TfNSW Reference: SYD21/00188/03

DPIE Reference: SSD-14378717

EXHIBITION OF EIS FOR TELOPEA CONCEPT PLAN AND STAGE 1A RESIDENTIAL, RETAIL, CHILD CARE AND AGED CARE - ADDERTON ROAD, TELOPEA

DRAWING TITLE
STAGE 2 - BLDG. E
ELEVATIONS

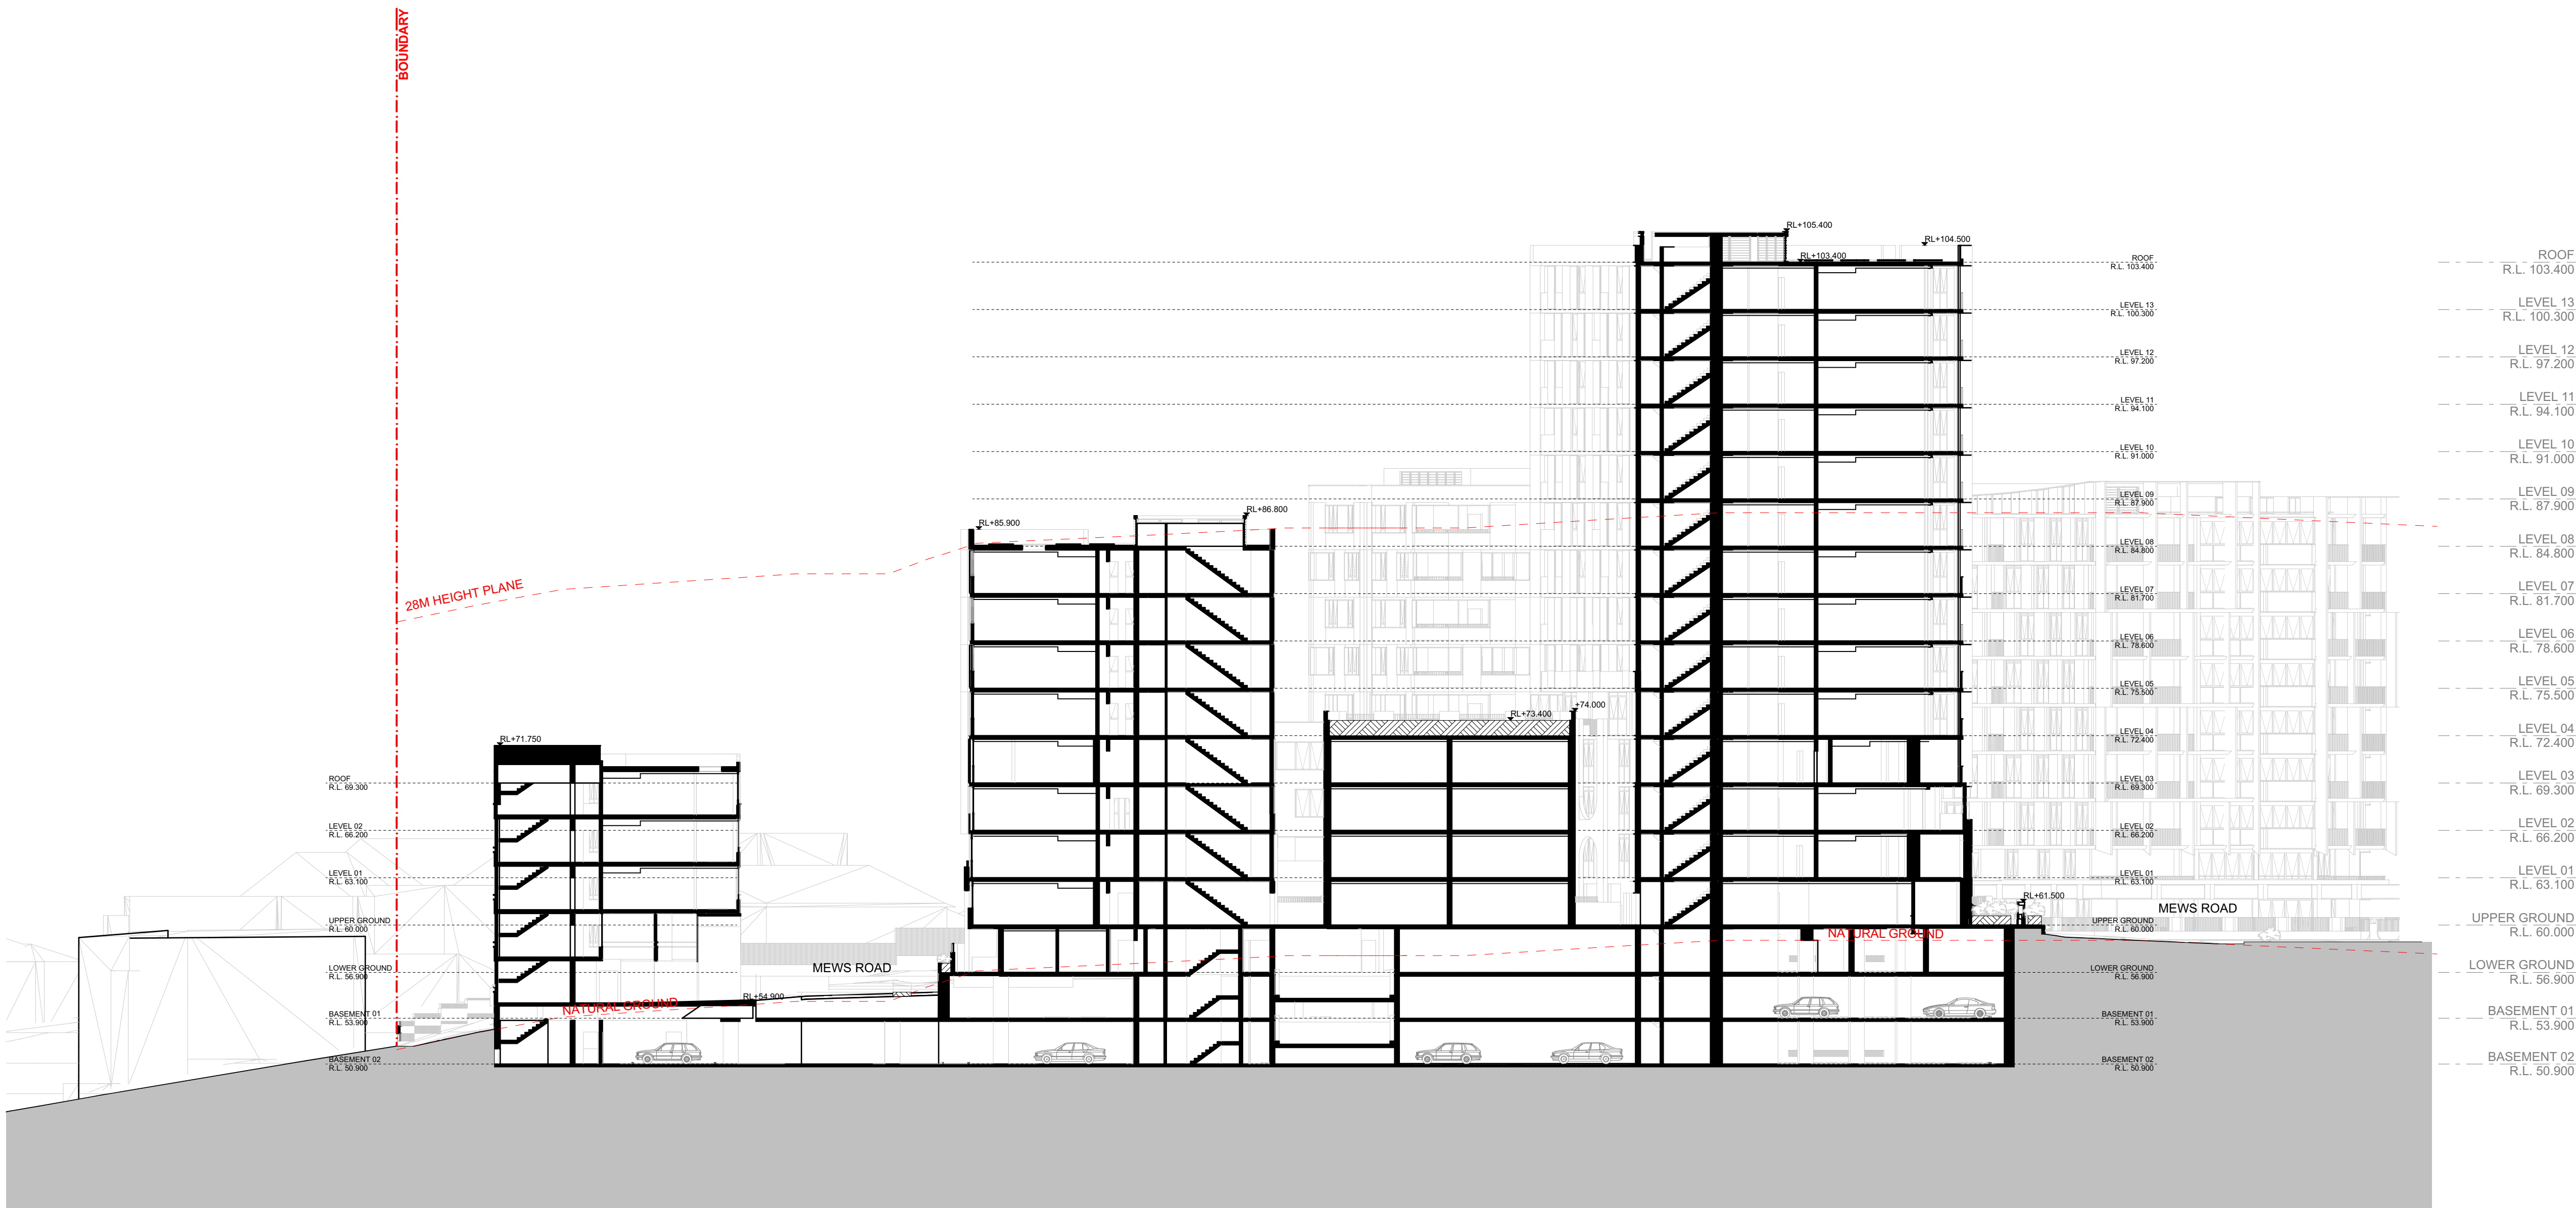
24. The design for openings such as balconies and windows on Building E will require risk mitigation of debris being thrown onto rail infrastructure. The Applicant is requested to provide updated drawings/details for Building E, showing anti-throw mechanisms for openings etc. (windows, balconies, terraces, roof top facilities and the like) within 20m facing the rail corridor in accordance with protection of rail corridors in Asset Standards Authority (ASA) Technical Guidelines T HR CI 12090 ST and Development near Rail Corridors and Busy Roads – Interim Guideline.
